Our Ref: 2020/246957

Your Ref: SSI-10038

City of Sydney submission on Sydney Metro West Concept and Stage 1 - EIS

Figure 2-2: Planned growth areas in the Greater Parramatta to Sydney CBD corridor

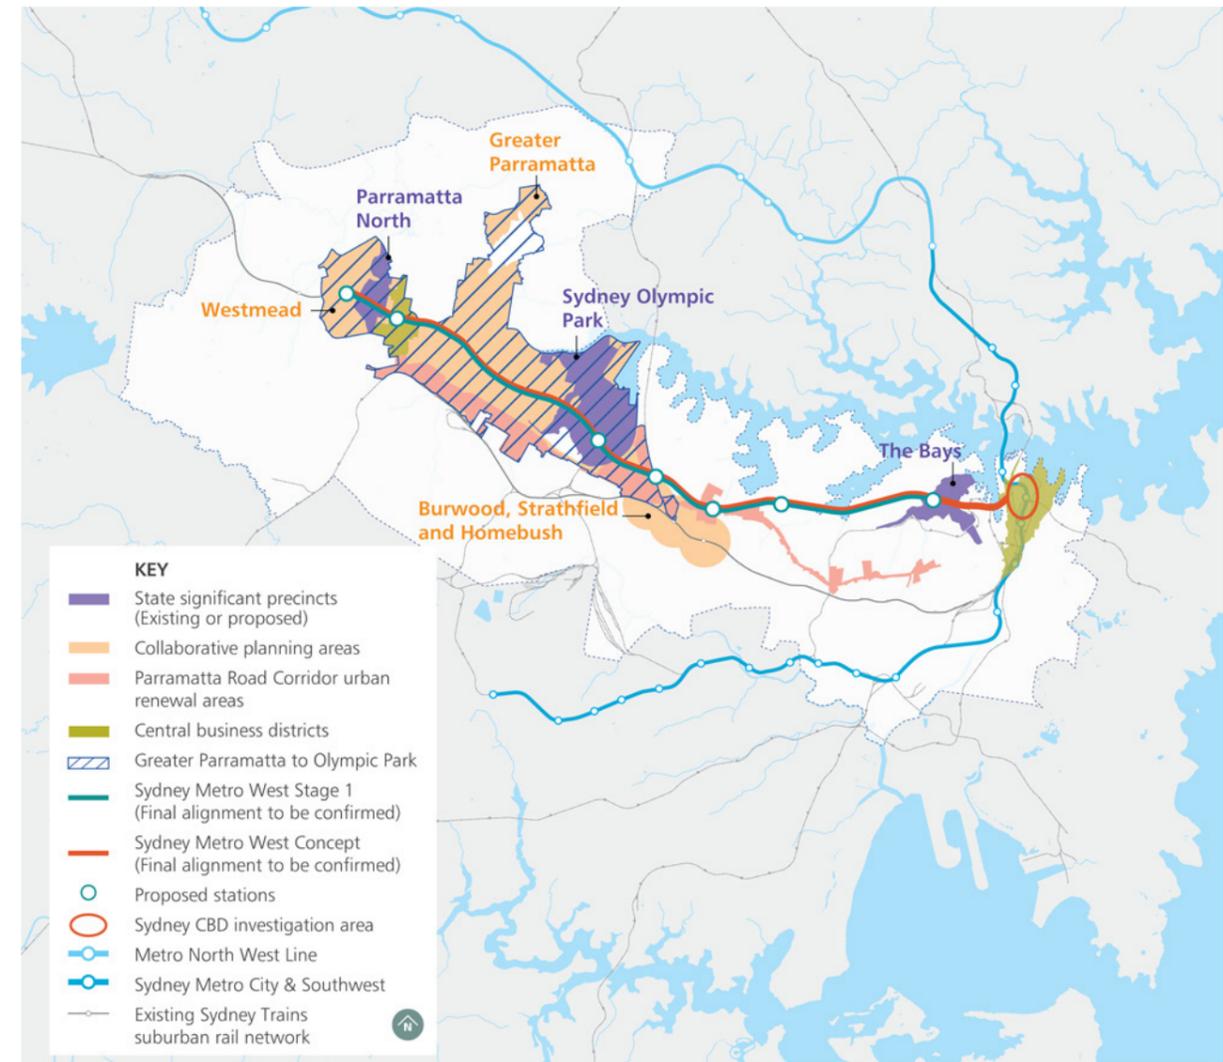
However, the map of "planned growth areas" at Figure 2.2 does not identify this – Pyrmont is not identified as a significant site, despite its existing high employment and

resident population and its potential employment growth under the Pyrmont Peninsula Place Strategy.

Failure to identify the potential opportunity in this key graphic suggests a disconnect between the project and broader placed based processes.
